**Consultation Response from KC,
Lead Local Flood Authority****2023/91405 Part of former St Luke's Hospital site, Blackmoorfoot Road, Crosland Moor,
Huddersfield, HD4 5RA****Erection of foodstore (class E) with associated access, parking, servicing area and
landscaping****Date Responded: 30/01/2024.****Responding Officer: Martin Stephenson****Responding Ref: 1****Documents reviewed by the LLFA:**

- Document Ref: 21561-FRA-001, Flood Risk Assessment, Rev F dated December 2023.
- Document Ref: 14.09.23 Network.mdx, Hydraulic Calculations dated 14/09/2023.

Proposed Impermeable Area Plan = 5800m²- Scale (NTS)

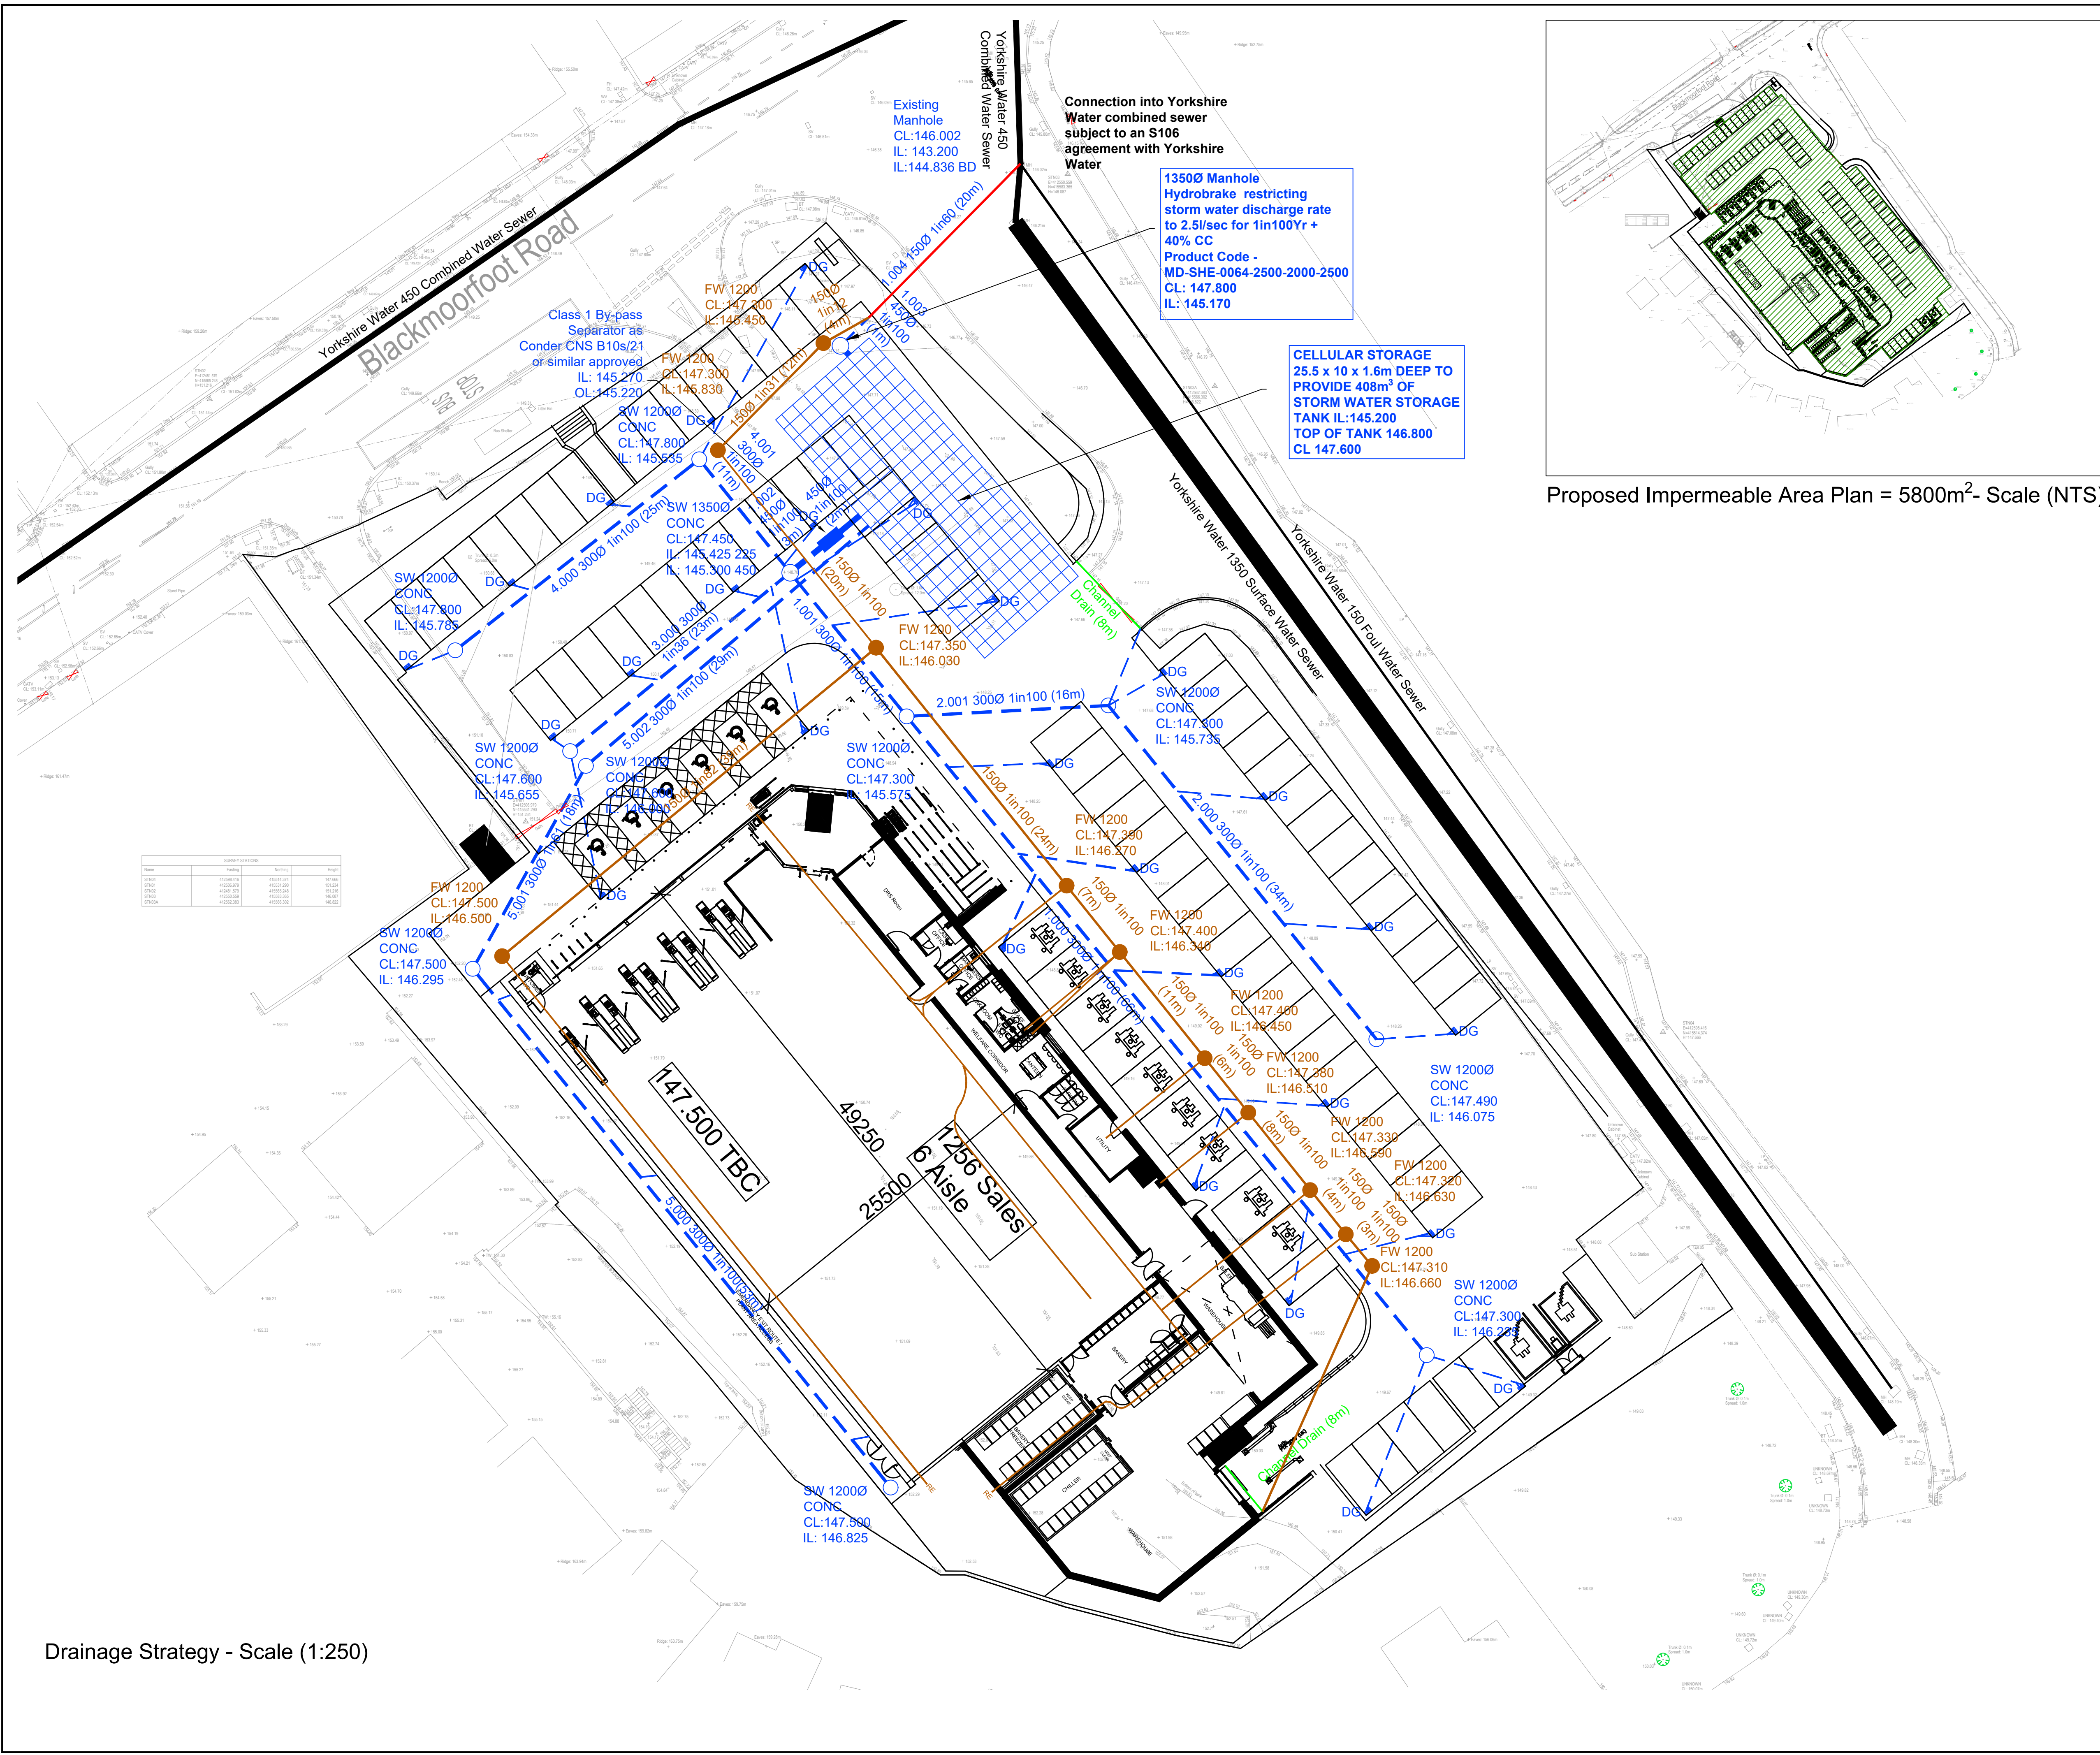
It is noted that in the FRA, it has been assumed the site is “brownfield” and that the surface water discharge from the site is to be limited to 70% of the pre-development run-off. The site can only be treated as brownfield if there is proof that the site had effective positive drainage within the last 3 years, otherwise the site should be considered as “greenfield” and the surface water drainage should therefore be attenuated to a GFRO rate of **5 l/s per ha** (subject to a minimum flow control device outlet diameter of 75mm).

As there are more than 50 car parking spaces, a suitably sized bypass oil separator should be provided for the run-off from hard standing areas – note that rainwater from roofed areas should not pass through the separator to avoid flushing out contaminants.
